Existing Coverage VS DO Upgrade

Markup Summary

Subject: Text Box
Page Label: 1
Author: dskendall
Date: 7/30/2018 3:11:21 PM
Color: ■

RE: Coverage With No DN70XC032 Site

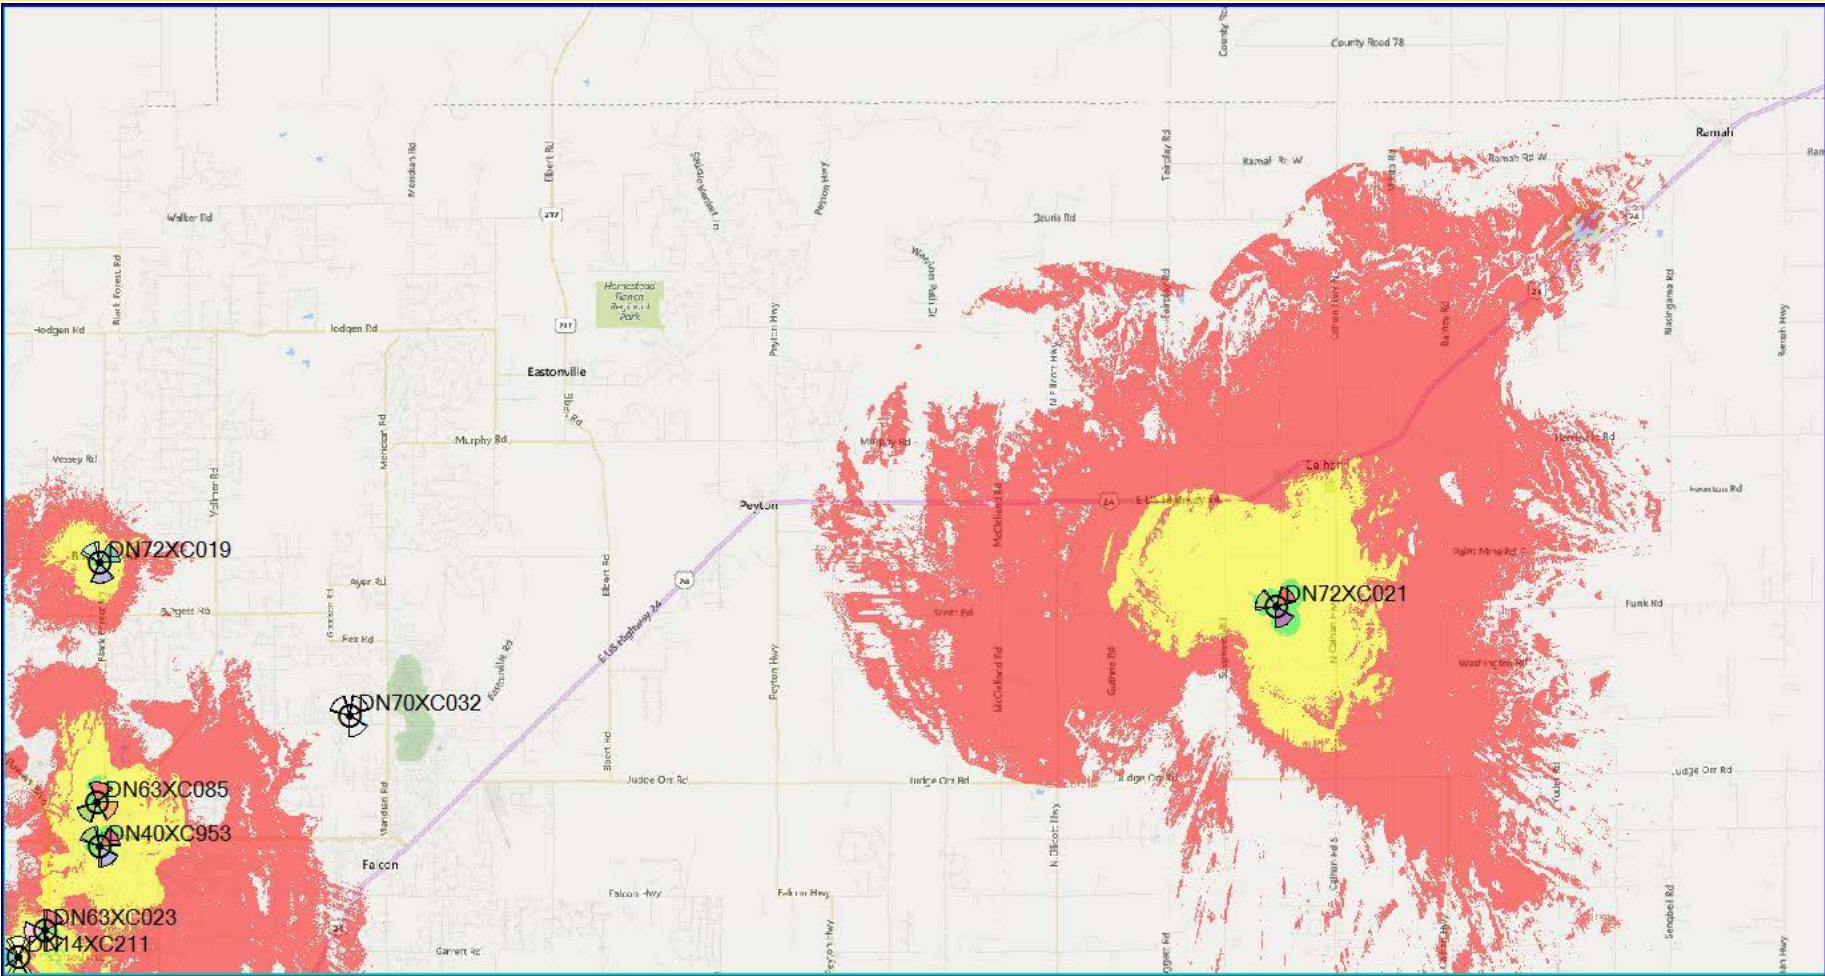
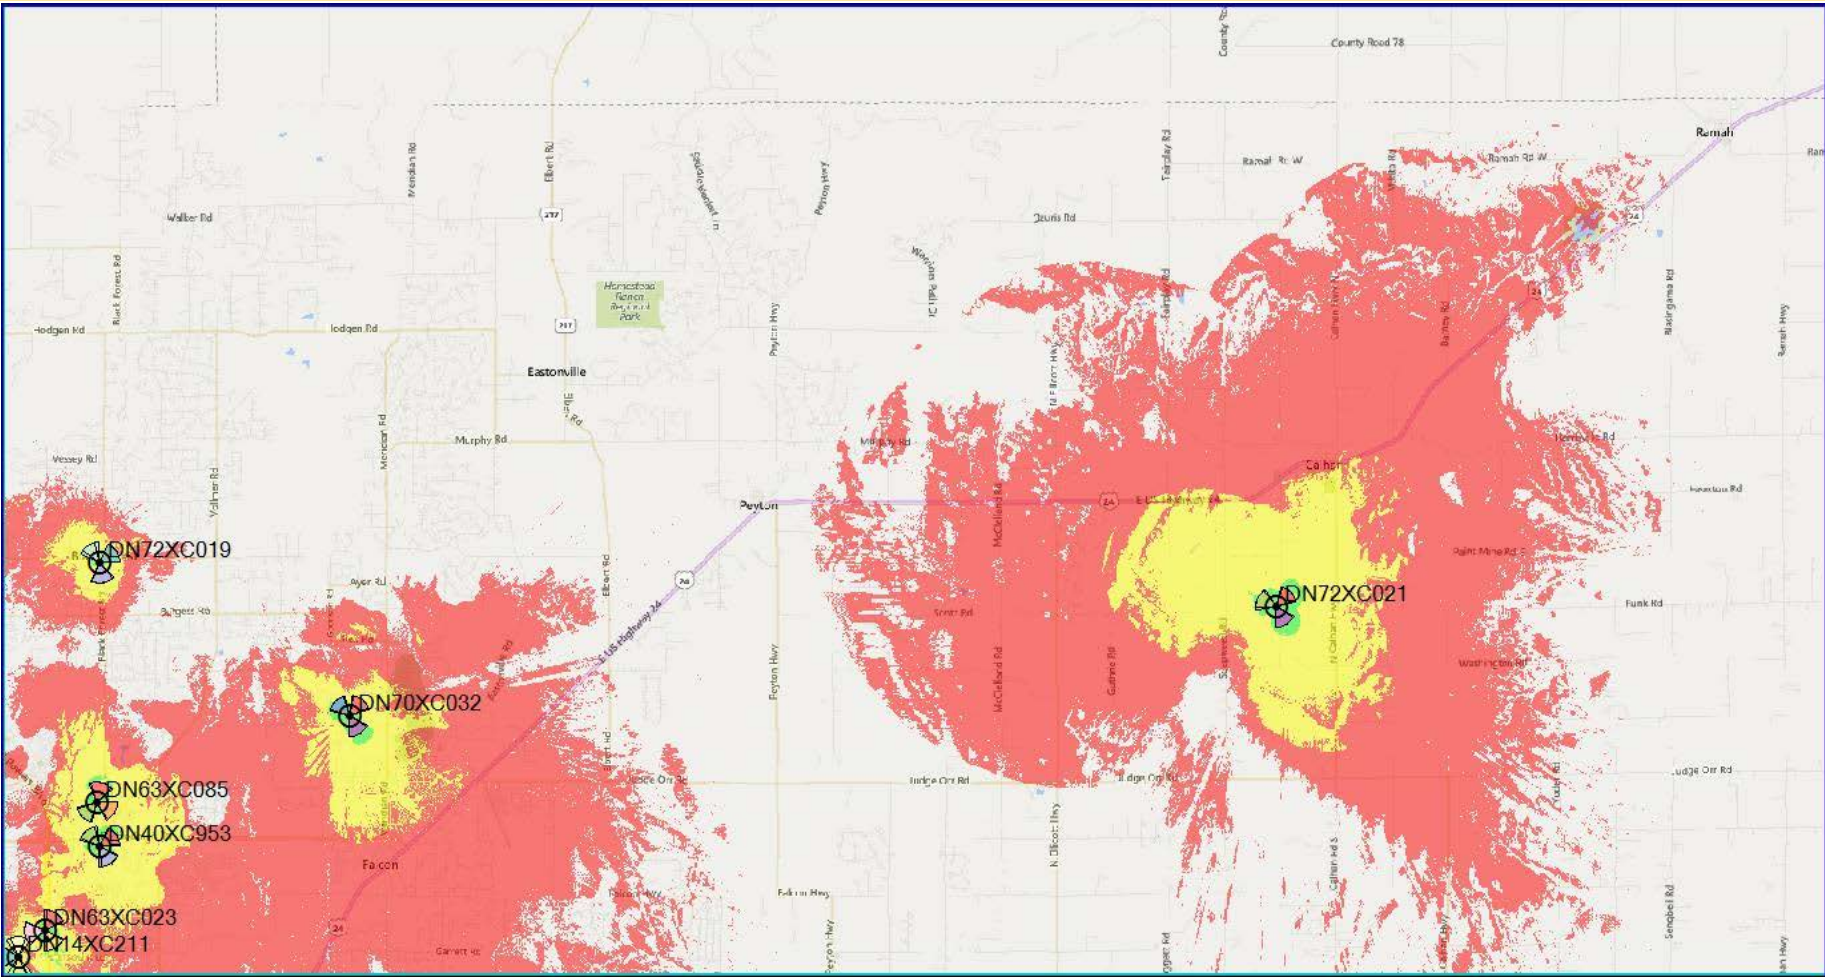
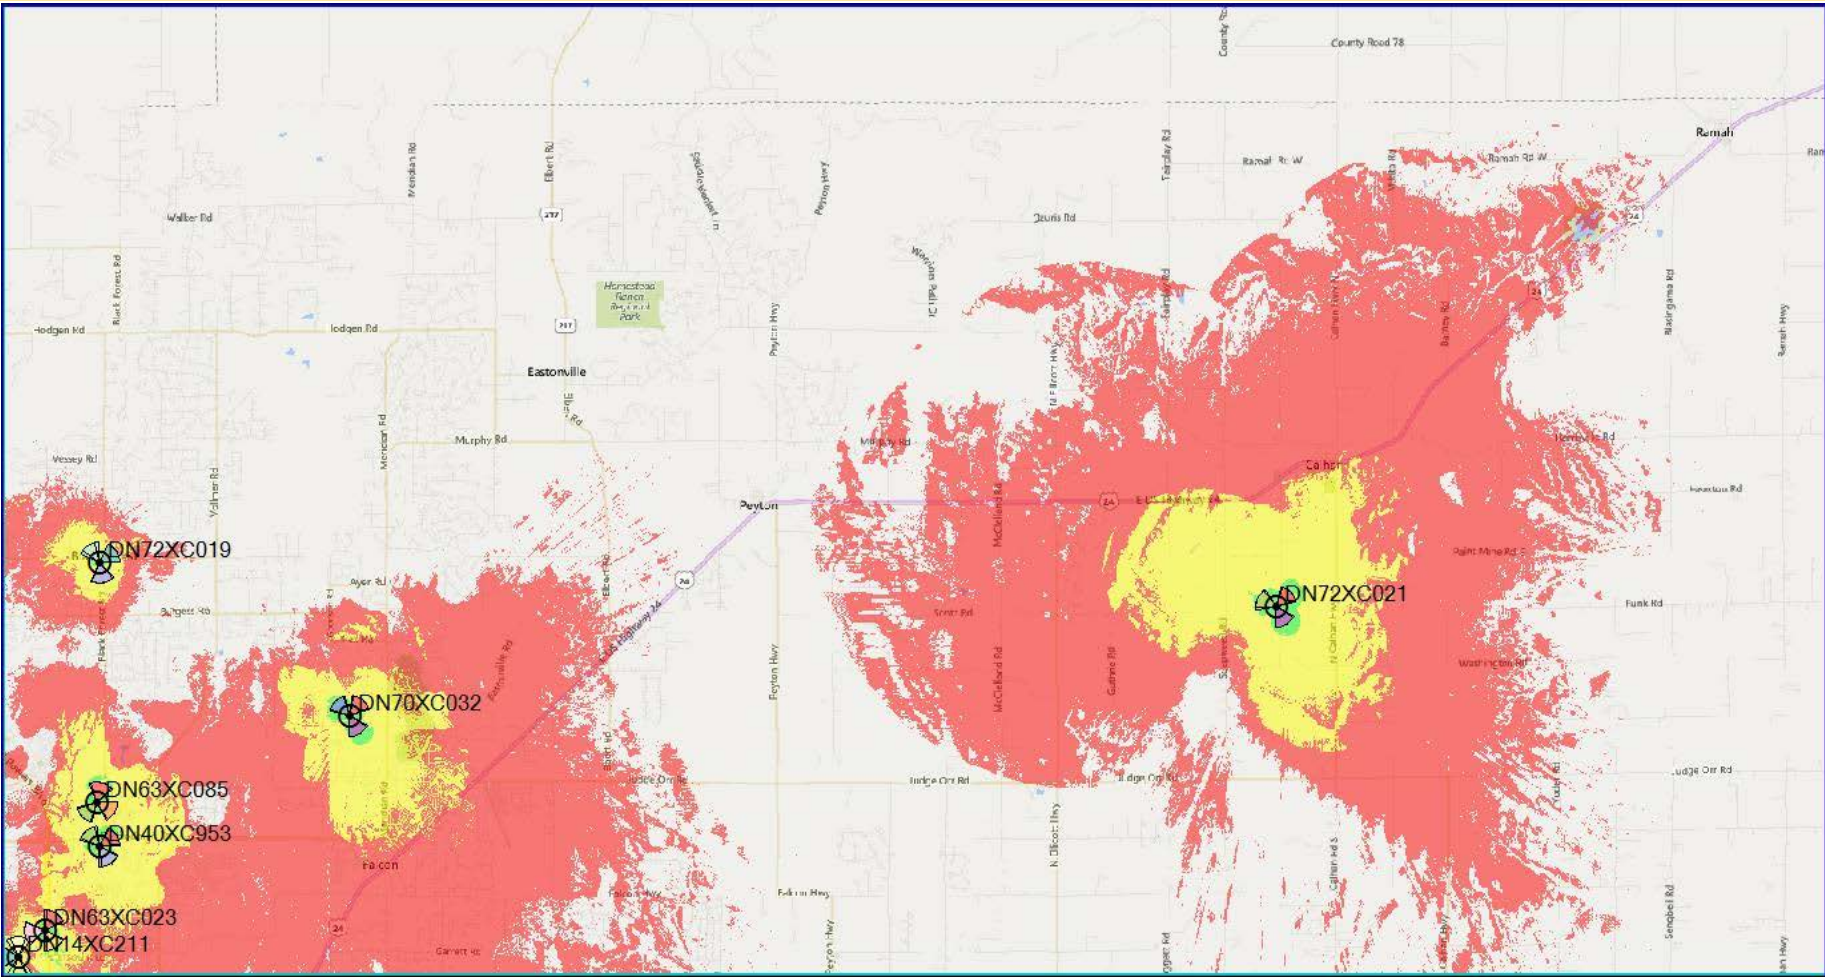
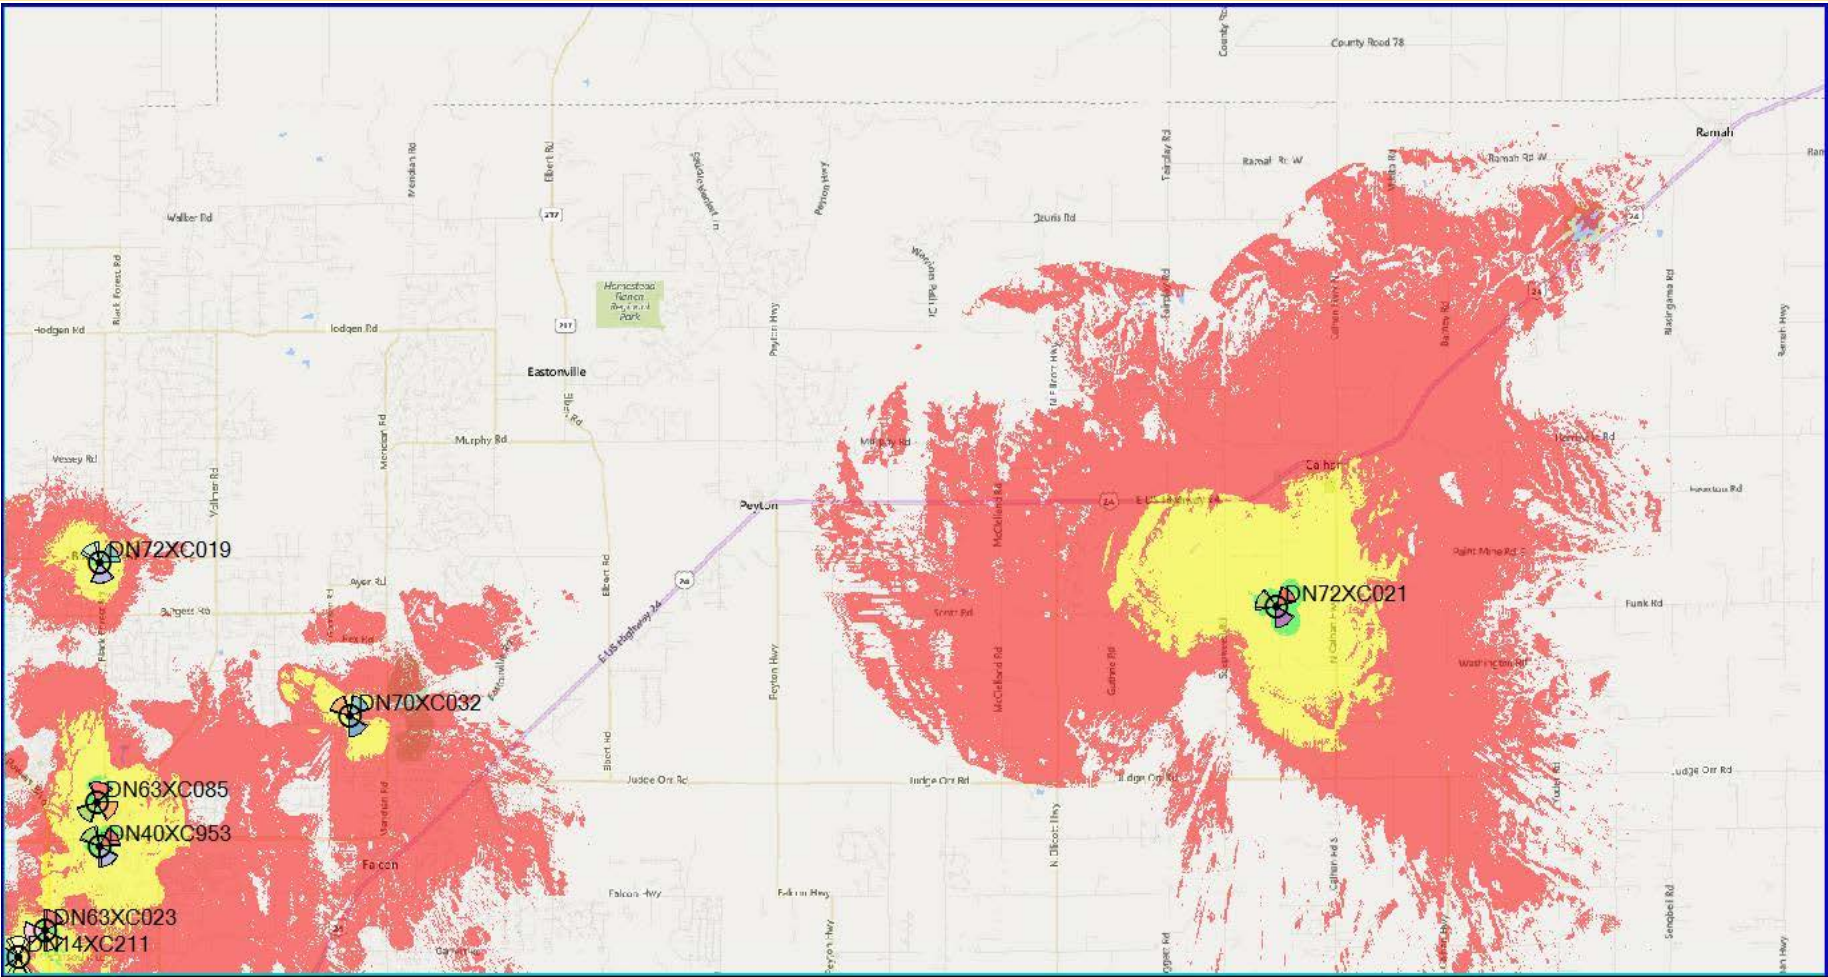
This should be more detailed, it should include a north arrow, a legend, and there should be multiples of these maps showing the antennae at different heights, to show why this coverage cannot be co-located on the existing, approved tower at Falcon School.
